Embrey Builders, LLC
 1020 N. E. Loop 410, Suite 700
 San Antonio, TX 78209
 Ph : (210) 824-6044 Fax: (210) 824-7656

RFI

RFI #: 128
 Date: 5/29/2012
 Job: EB-02 Keller Springs Lofts
 Phone: 877-777-5115

Subject: Corridor duct issues

SHEET NUMBER
3.1C
BLDG PLAN 'C'

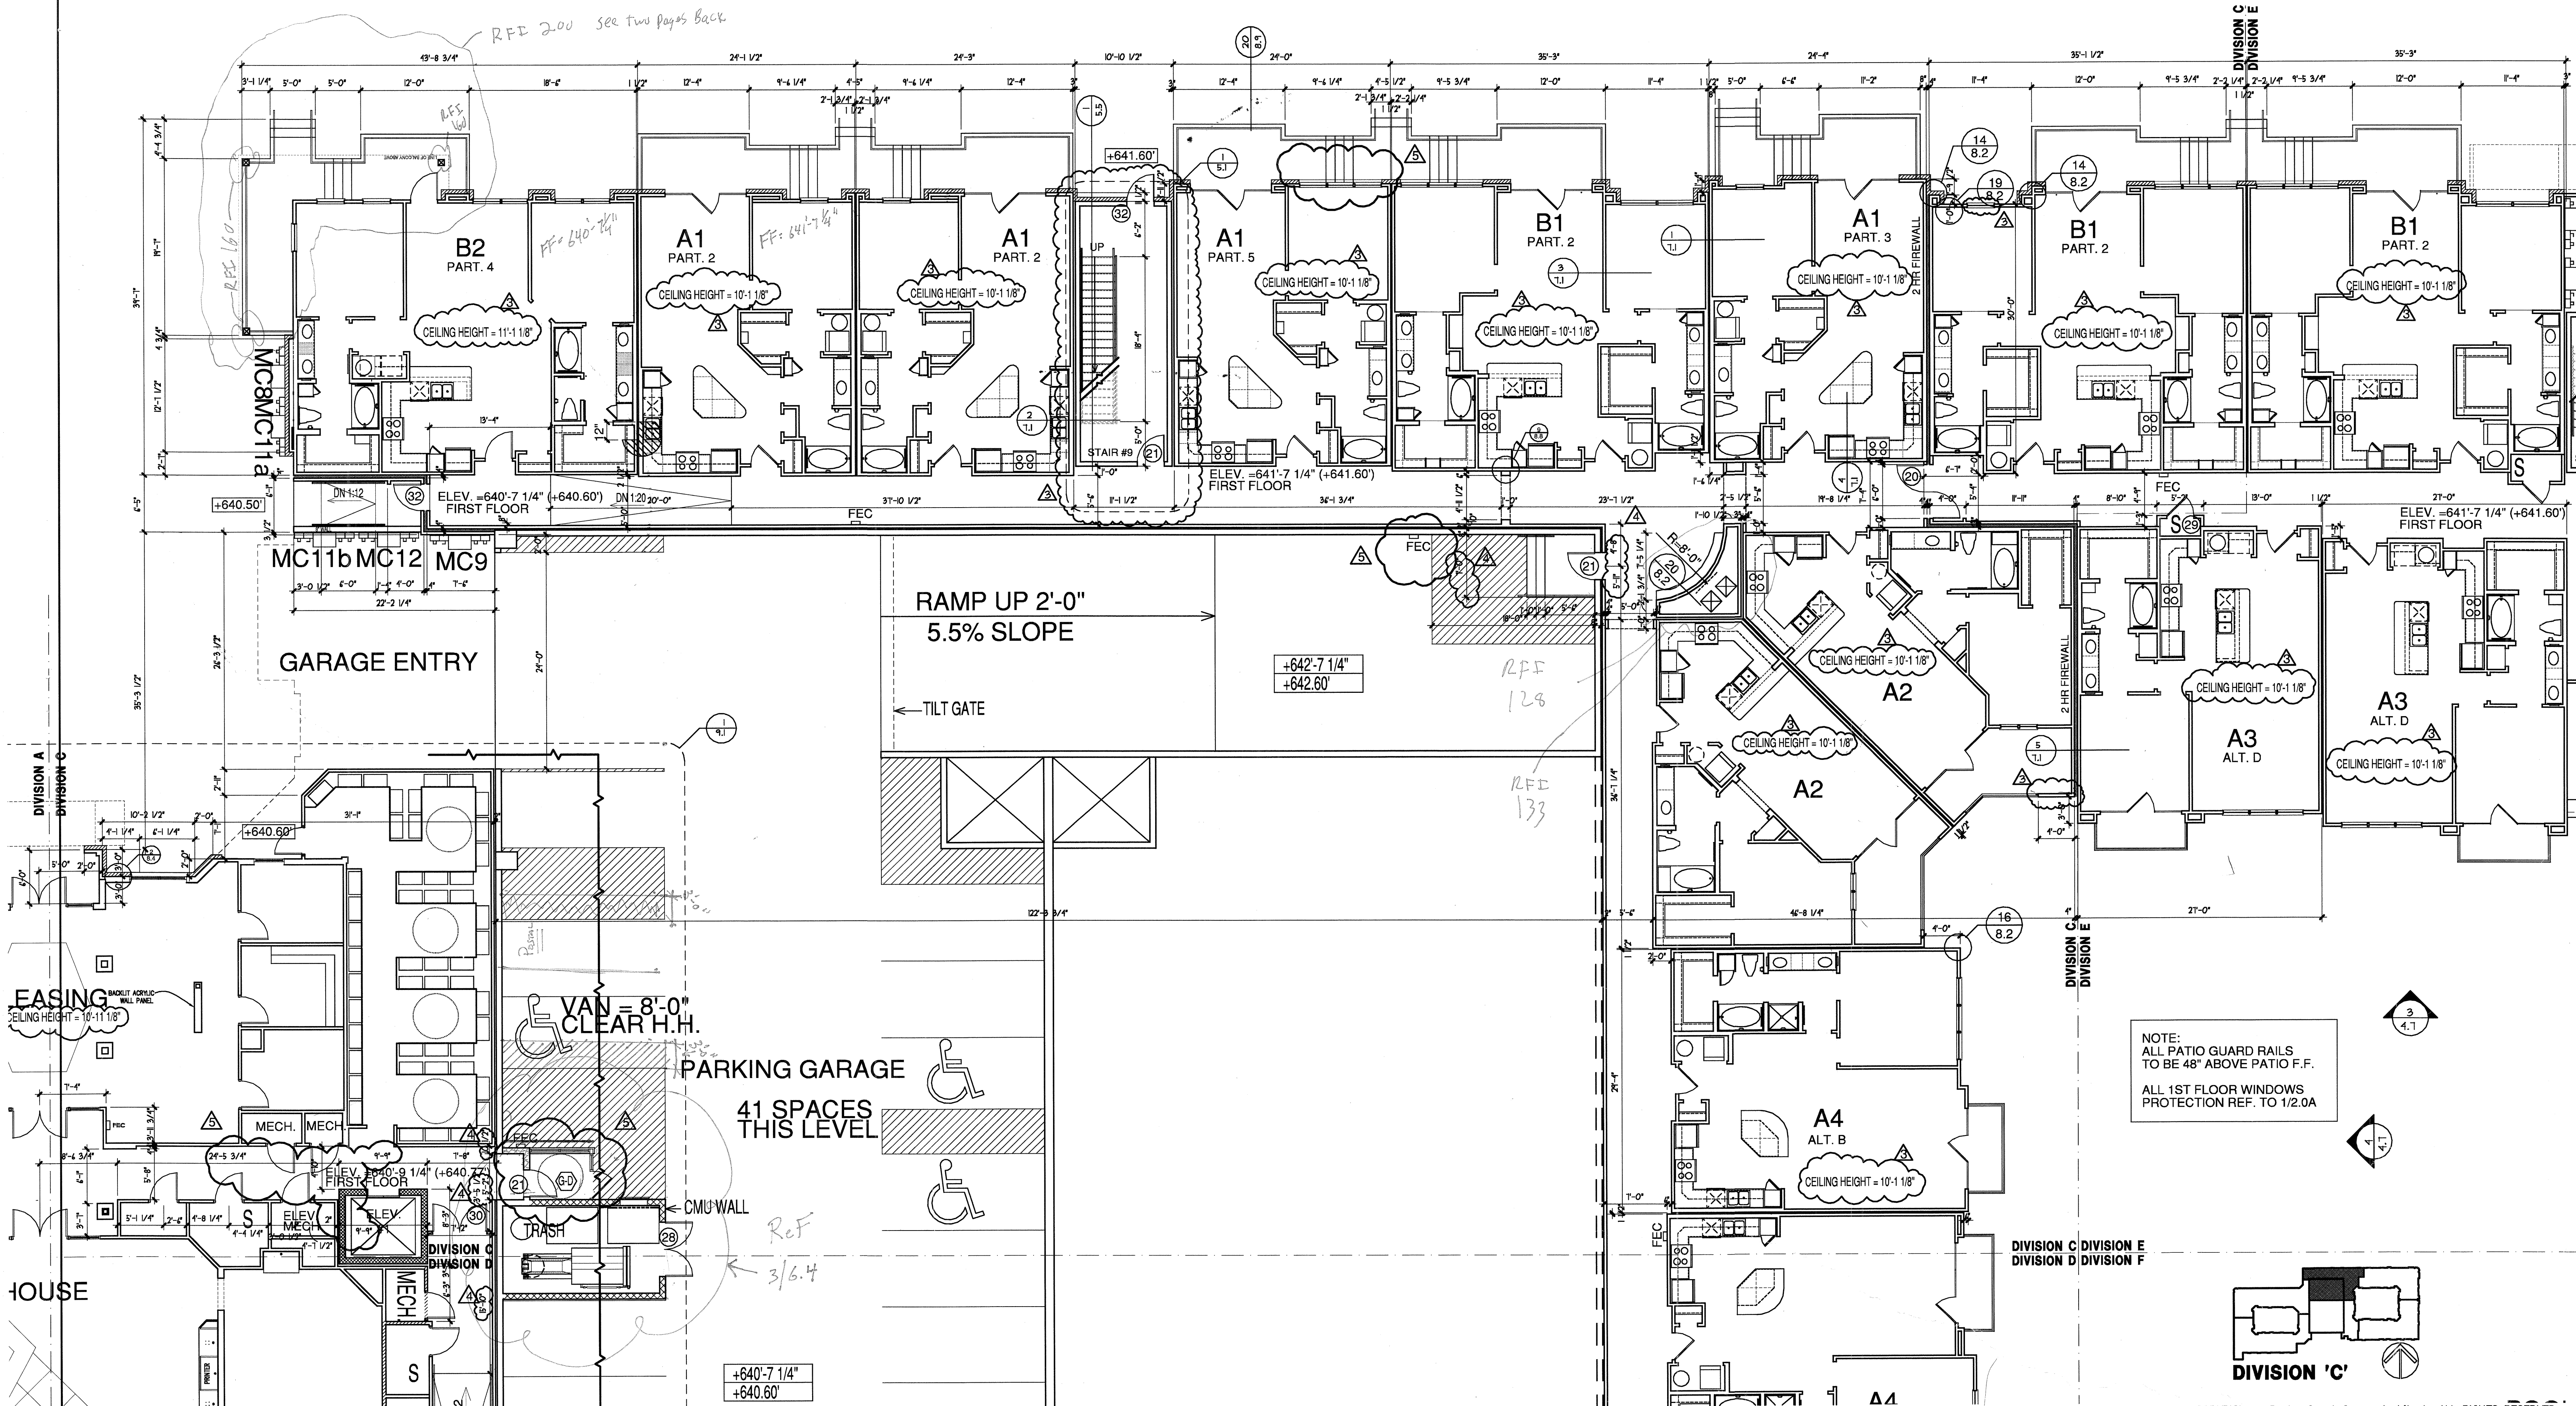
Request:
 Sheet 3.1C shows a dimension of 122'-3 3/4" for width of garage from outside 8" pre-cast wall to outside pre-cast wall. All other plan sheets show this to be 122'-4" (see 3.1D, SG2.01, PC-01)

Response:
 Coordinate the 1/4" difference with the architect. Please let PPO if we need to revise the dimension on the structural drawings.
 If you have questions or require additional information regarding this matter, please do not hesitate to contact us.

The overall of the garage is 122'-4" as noted on sheets 6.2, 6.3, 6.4
 E Earnshaw BGO Architects 01-05-2012
